Ribble Valley Borough Council
Housing & Development Control

Application no: **3/2020/0675**

Address: **Ribble Valley Care Home Sawley Old Brow Sawley BB7 4LF**

Proposal: **Part demolition of bedrooms to rear of building and full demolition of existing conservatory to the main entrance area. Construction of walls under existing canopy at entrance door, erection of new sunroom in place of demolished conservatory and construction of new single storey extension to rear of property replacing partly demolished structures and associated parking**

Proposed Site Plan
Scale 1:500

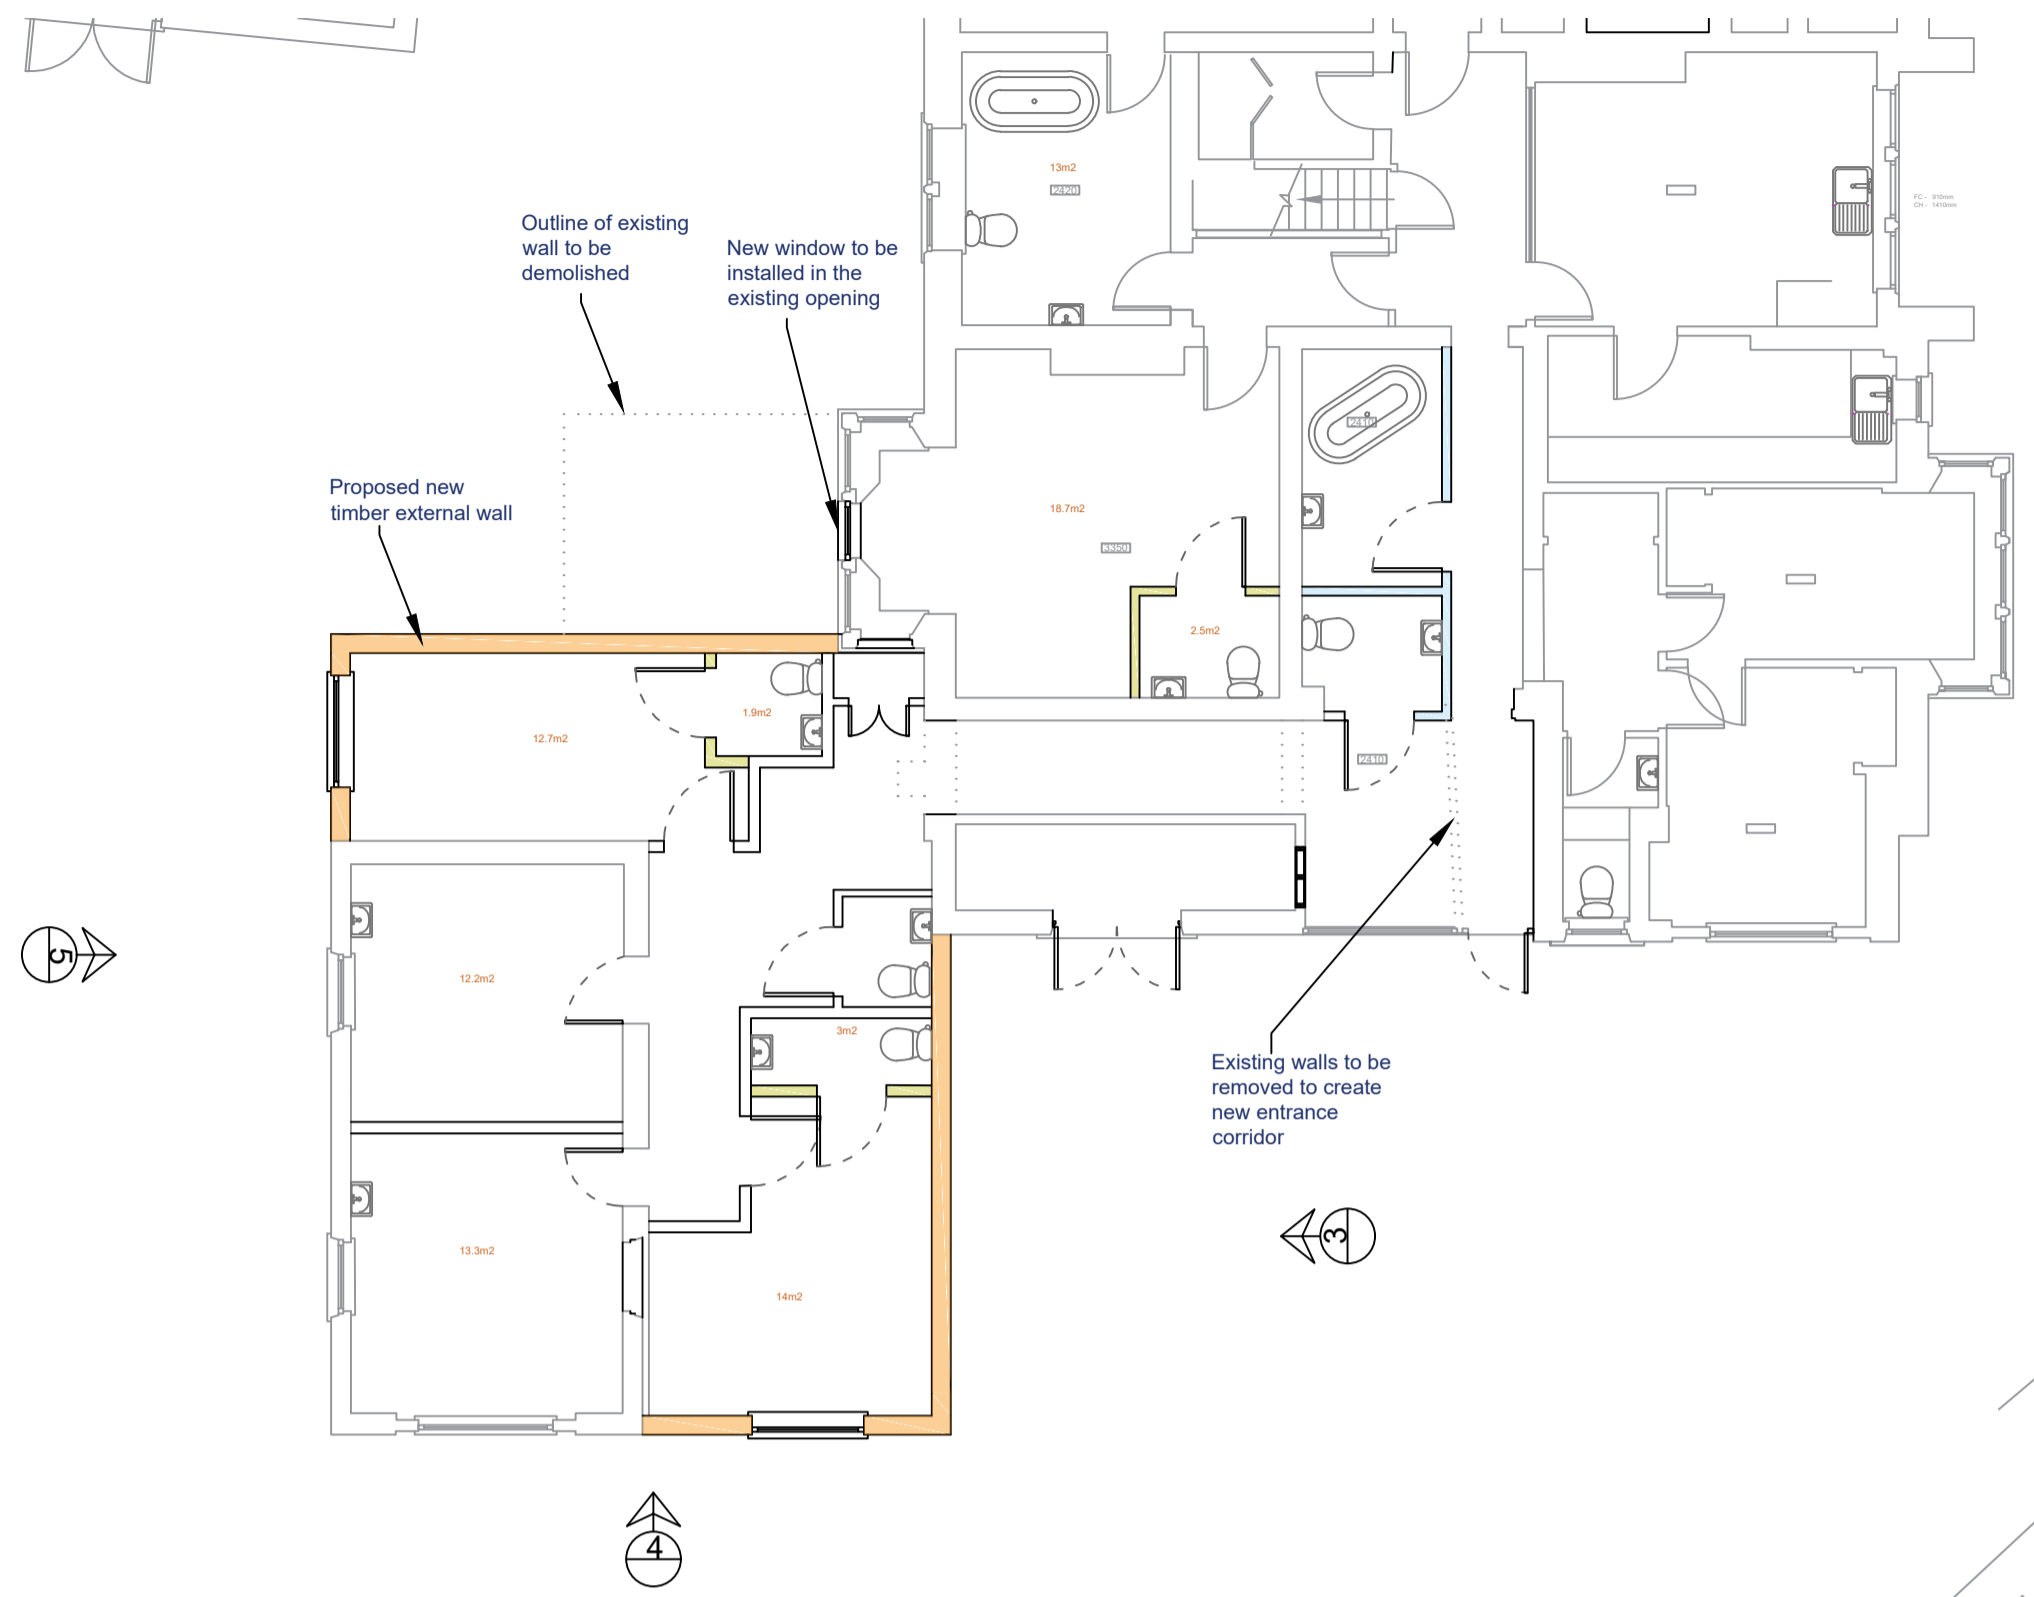
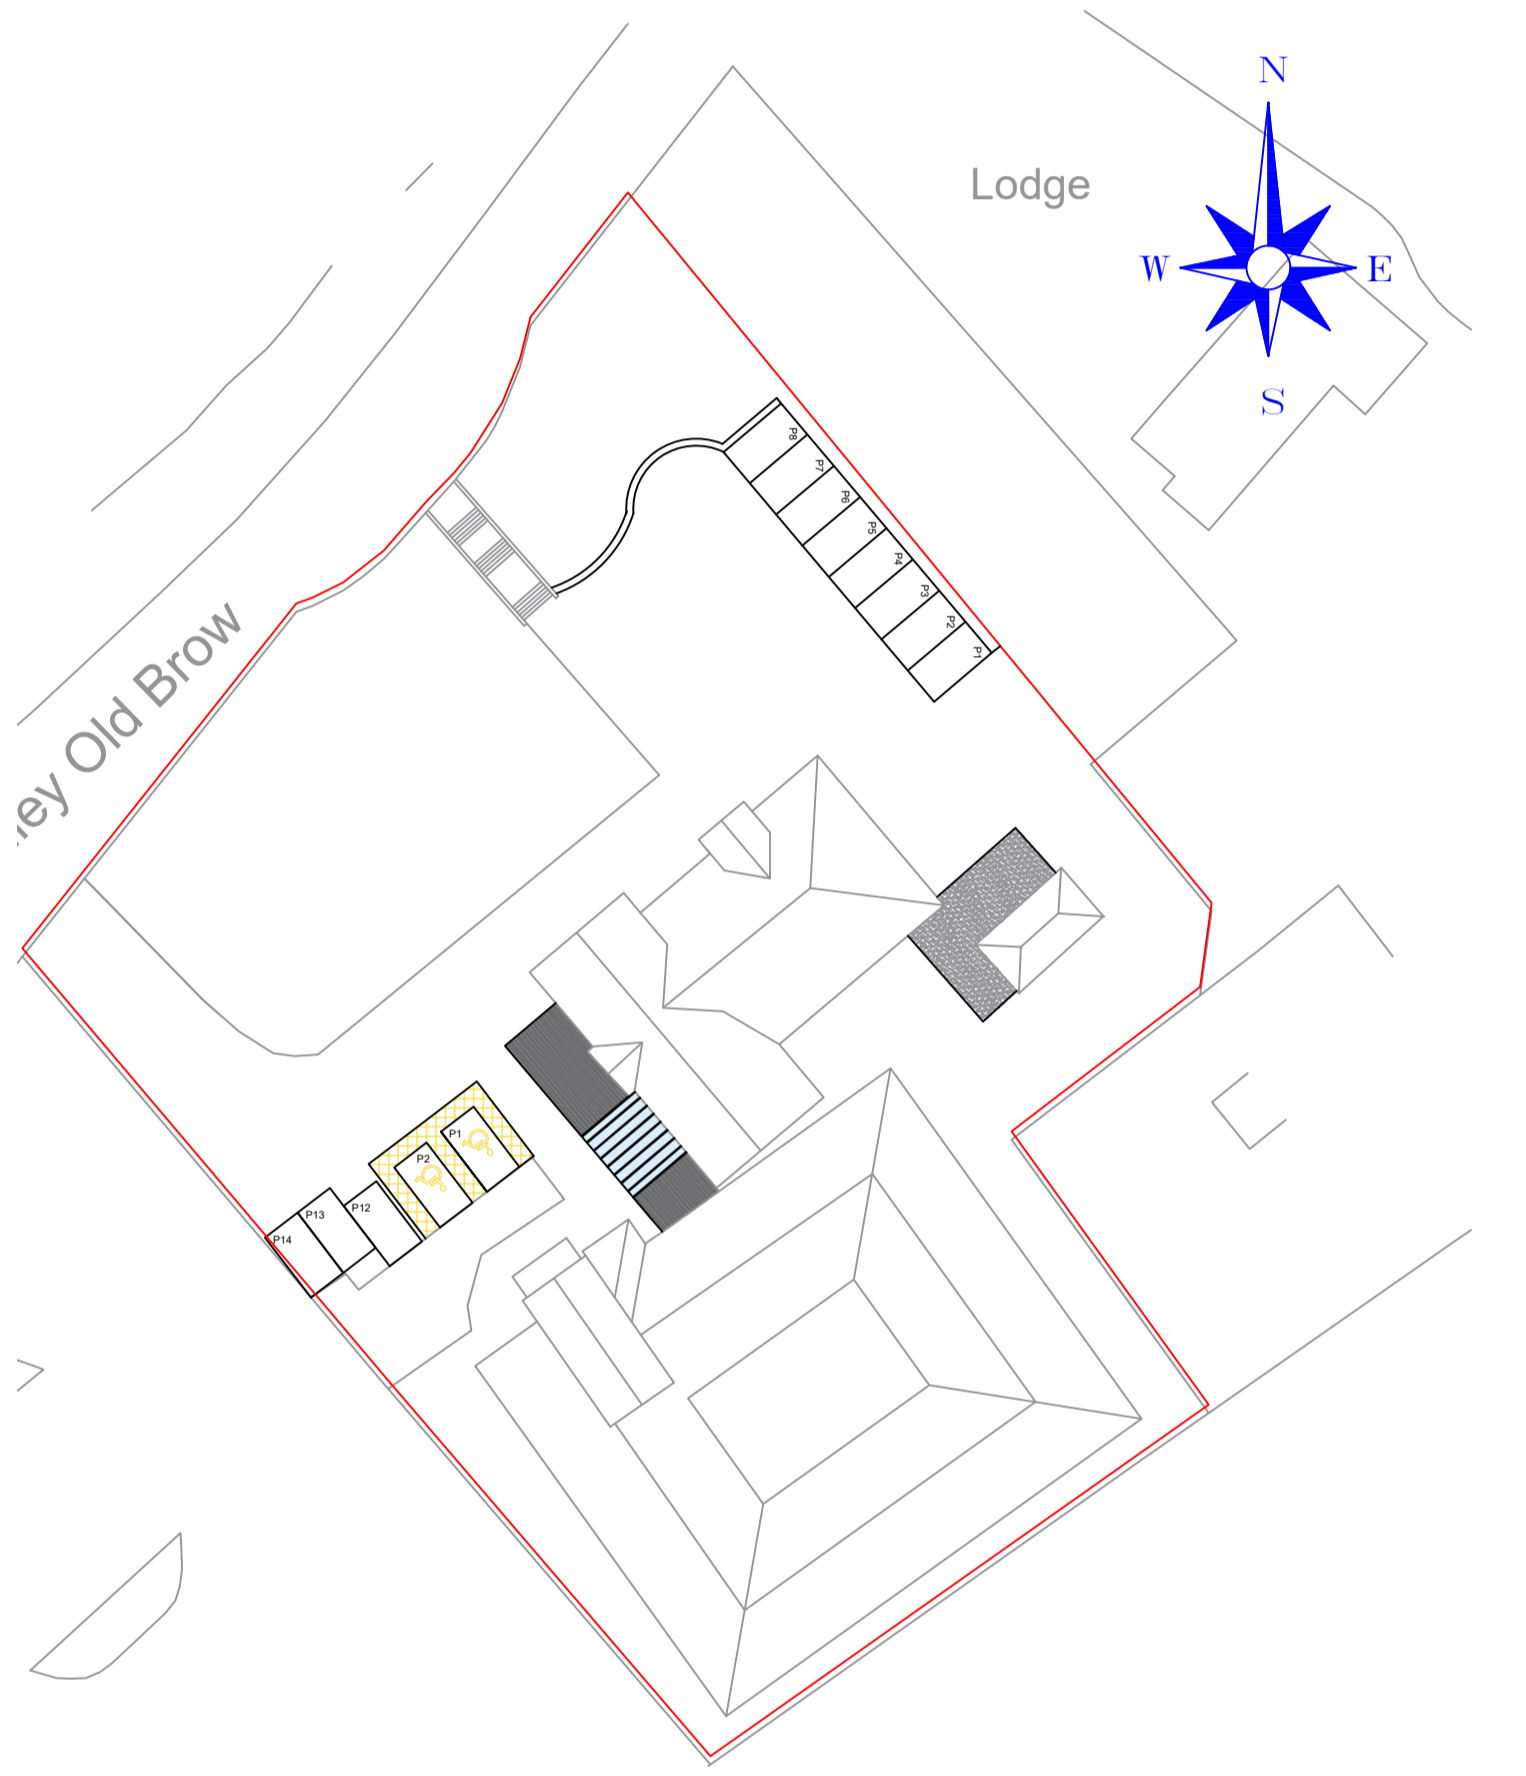
In accordance with the revised proposed site layout, drawing number 005 Rev A, I would raise no objection to the proposal on highway grounds.
